Tower Club/Coco Lounge
8-10 Clifton Road
Littlehampton
West Sussex
BN17 5AS

Our Ref: LU/264/18/PL
Your Ref:

Development Change of use from redundant function room to office.
Location 8 - 10 Clifton Road Littlehampton

ama architectural & quantity surveying services address of works: 8-10 Clifton Road, Littlehampton			
Drawing title: Planning permission for change of use			
Date: Oct. 2018	Scales: As shown	Paper size: A1	Dwg No: AR-132B-03

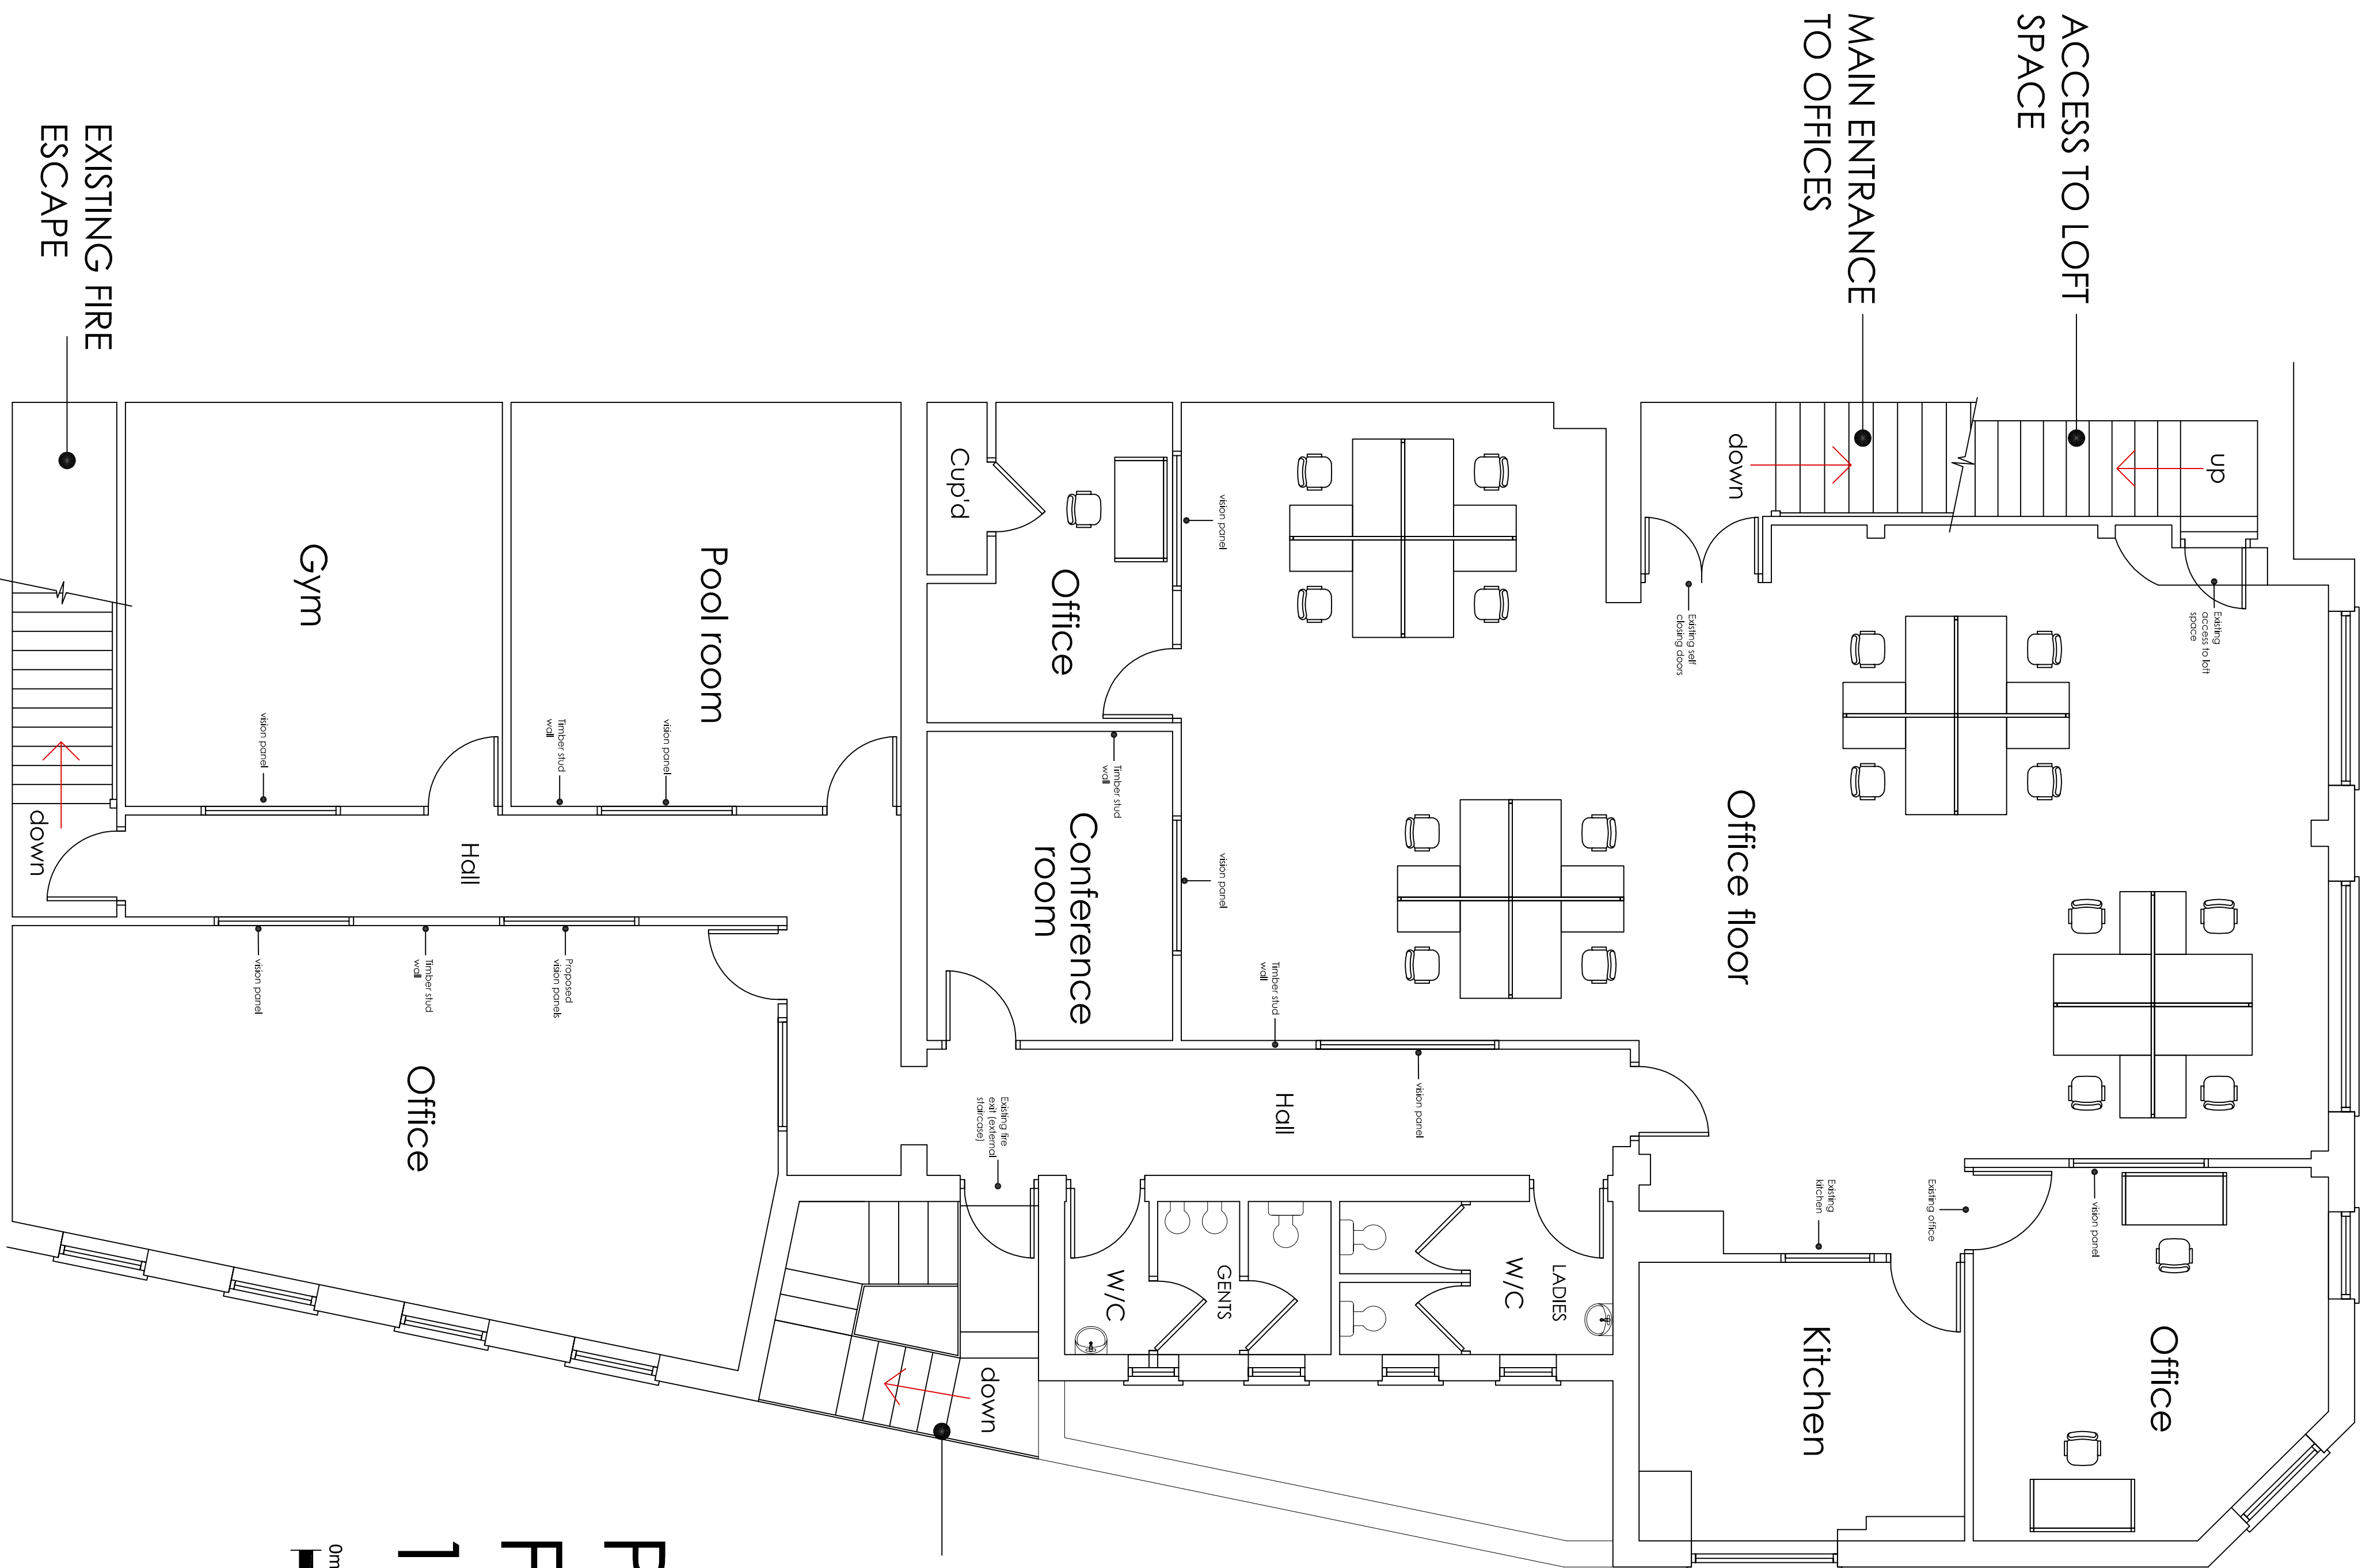
Location Plan Amend

Please red edge the application site and provide a scale.
